Town & Country Planning Act 1990 (as amended) s211 Notice
Application for Prior Notification of Work to Tree(s) in a Conservation Area

Development Willow (T1)- reduce and rebalance not cutting further than original pollard points to reduce weight of tree hanging over play area and public use garden.

Location The White Hart 32 Surrey Street Littlehampton

TI WILLOW

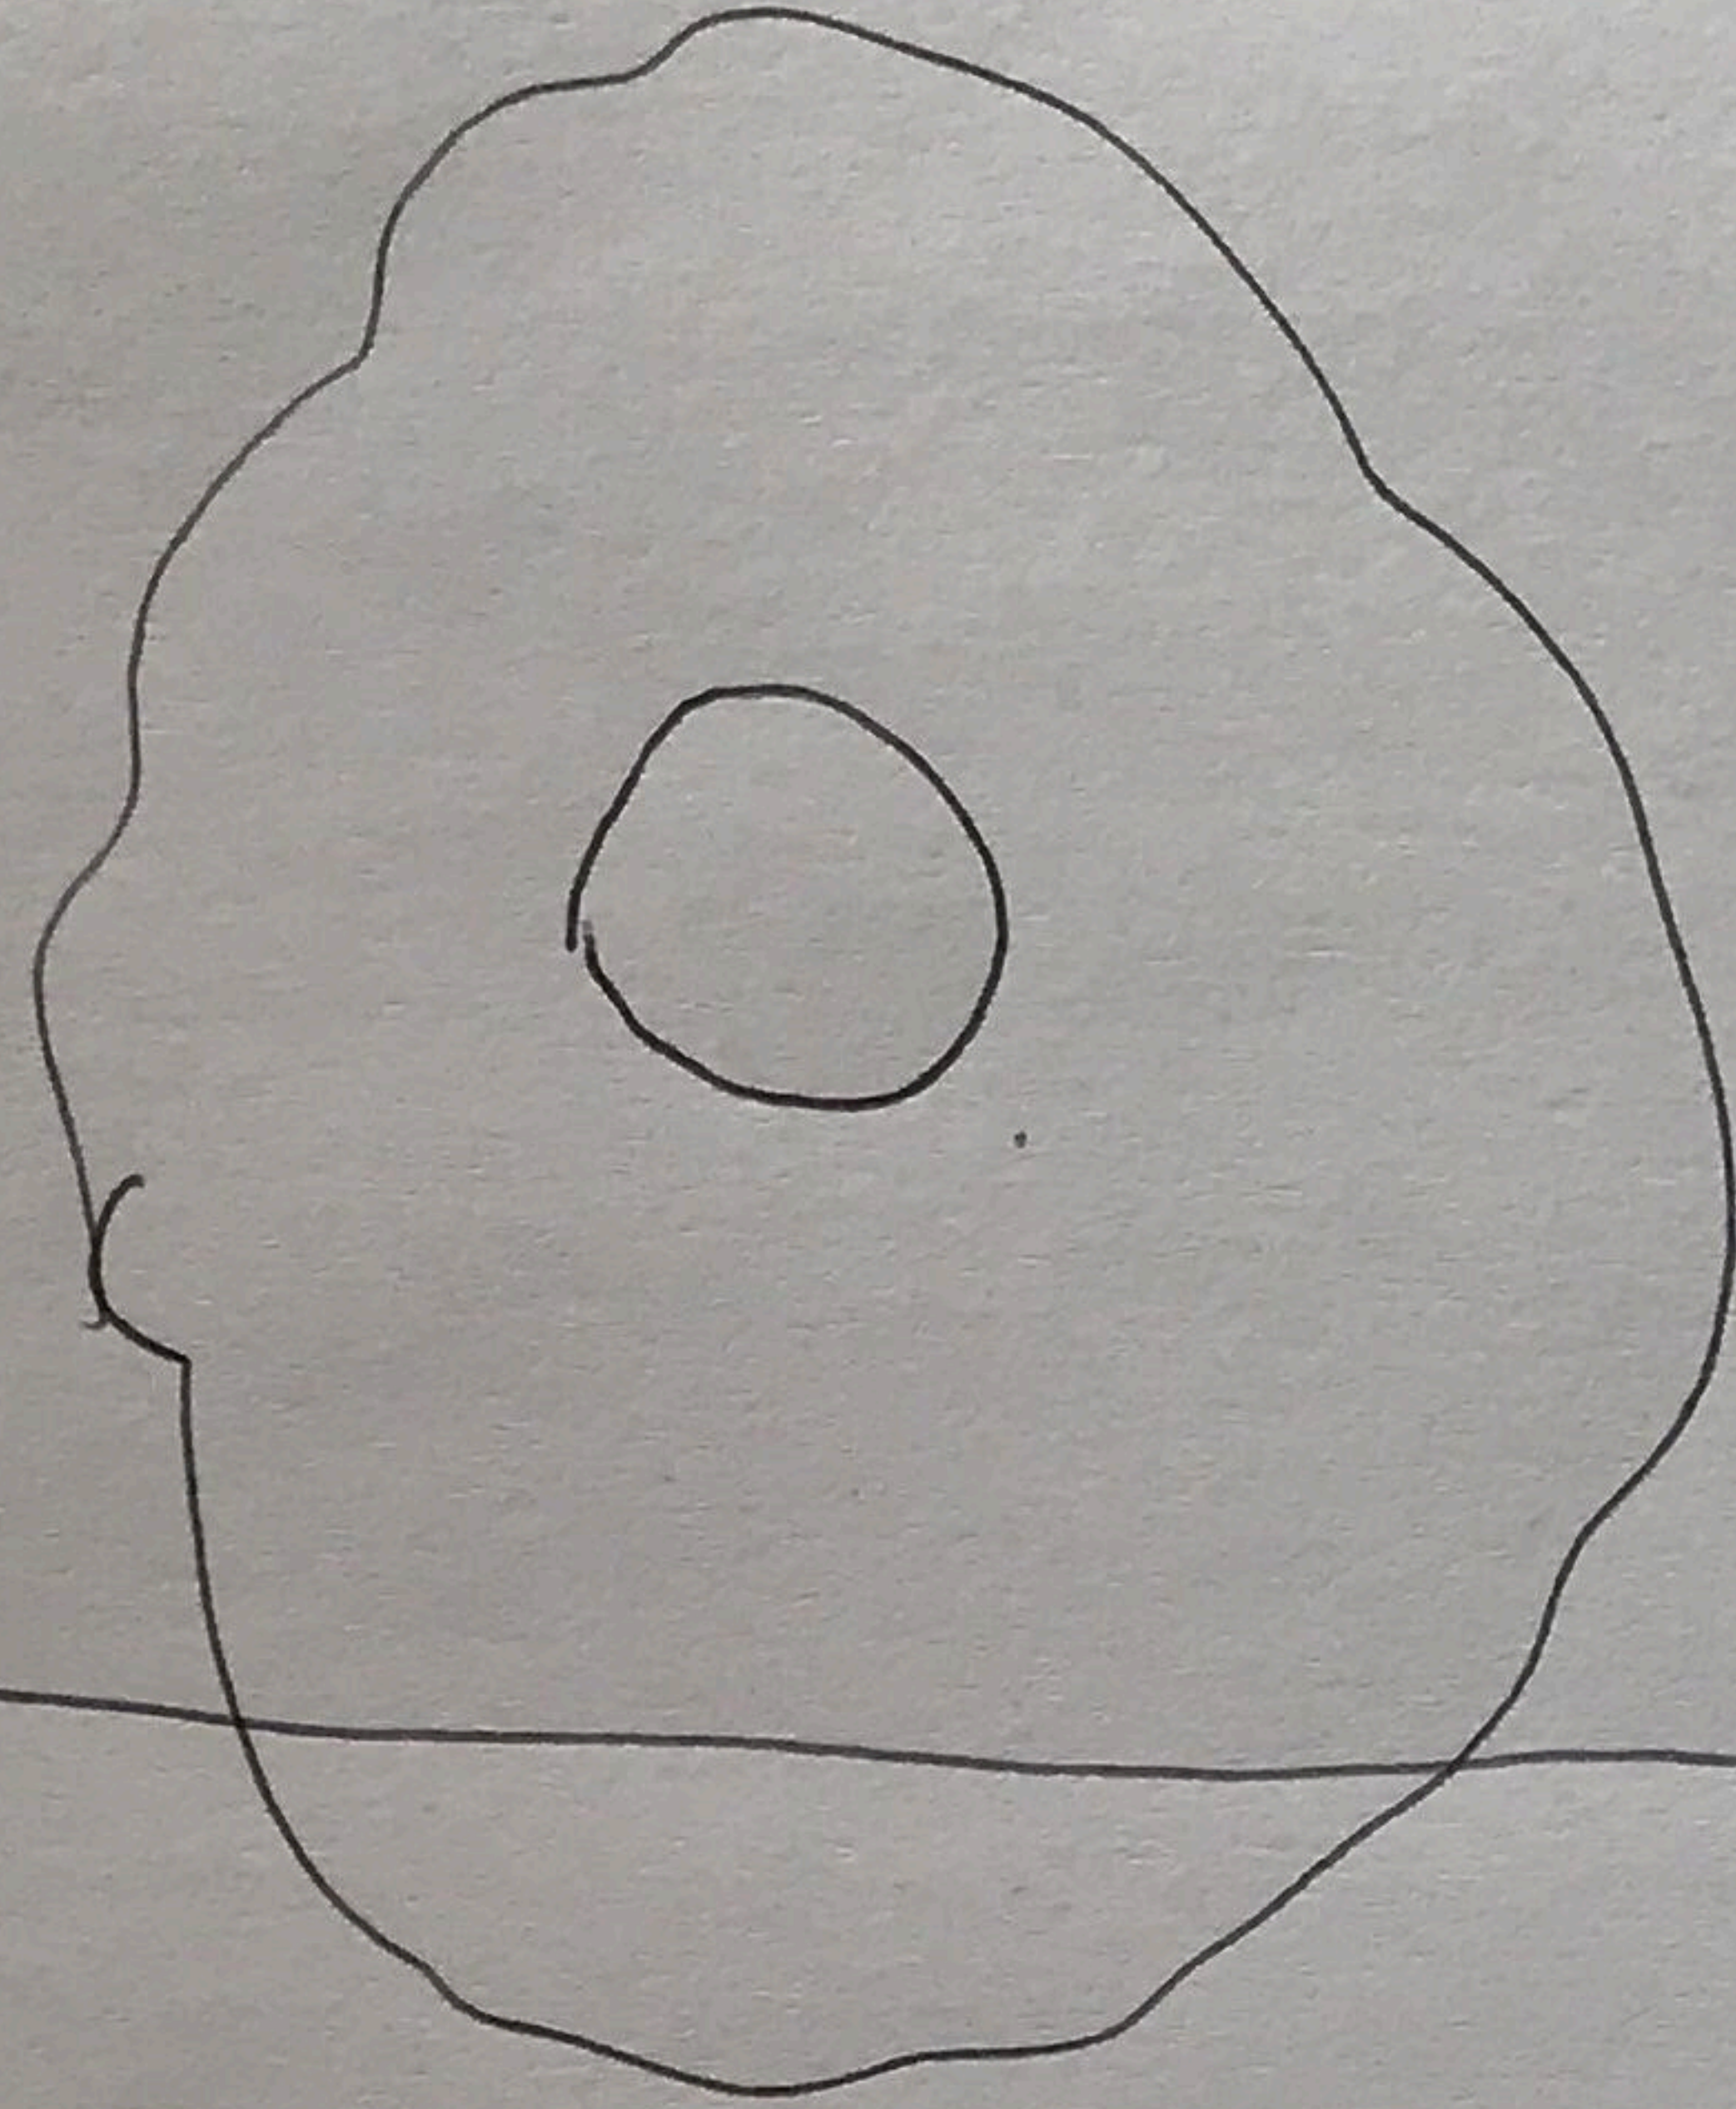
Please confirm the reduction in metres to 1 No. Willow tree.
